**Re: Desert Ridge Place Unit 3 -Abrazo  
Erosion and Sediment Control Plan  
Engineer's Stamp Date 4-12-18 (C20E076)**

Based upon the information provided in your submittal received 4-12-18, the above referenced plan is not approved to be included in the SWPPP or to apply for an ESC Permit for grading and Building Permit until the following comments are addressed:

**DESERT RIDGE PLACE UNIT 3**  
**TEMPORARY EROSION CONTROL PLAN MAP**  
 PROJECT TITLE

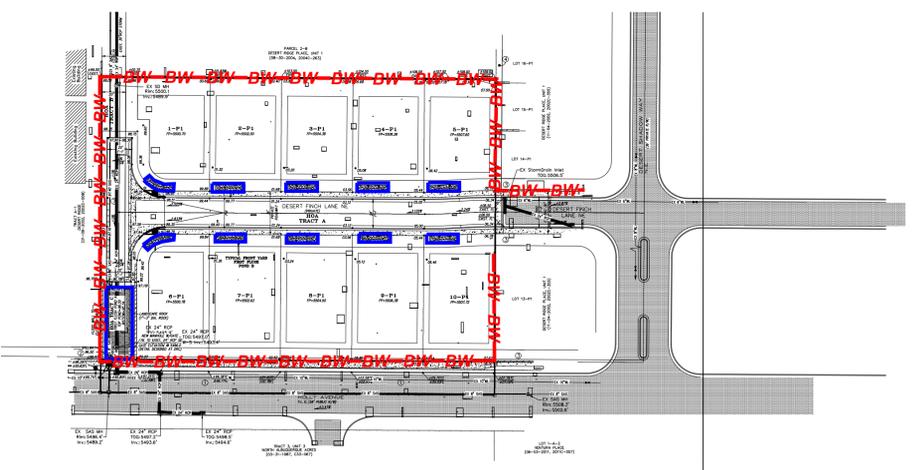
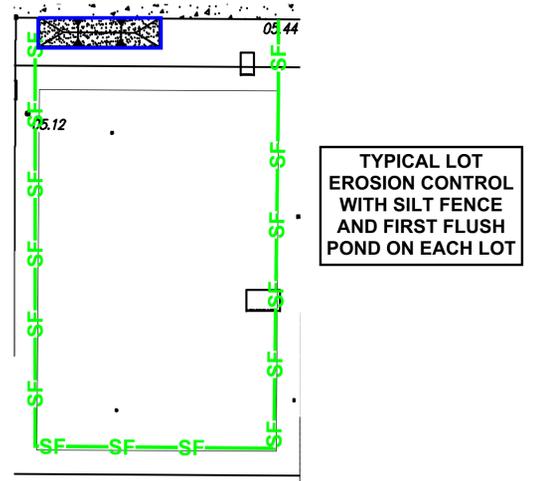
1. The main part of the plan does not show existing conditions properly. The site has a street, house pads and a pond. The site resembles the small drawing on the bottom of the page.
2. The typical lot detail does not include a sediment BMP at the front of the lot. Most builders are using a cutback behind the curb, but silt fence or mulch sock is acceptable.
3. Silt fence is not needed and most likely will not be installed at the back of the lot as there is a block wall in that location. In addition, silt fence along the high side of the lot seems unnecessary.
4. A track-out pad is shown on Holly Avenue. There is a block wall in this location.
5. The pond in the southwest corner has an opening into the storm drain system. Per as-built drawings it is approximately 9 inches above the bottom of the pond. Seems inlet protection should be installed.
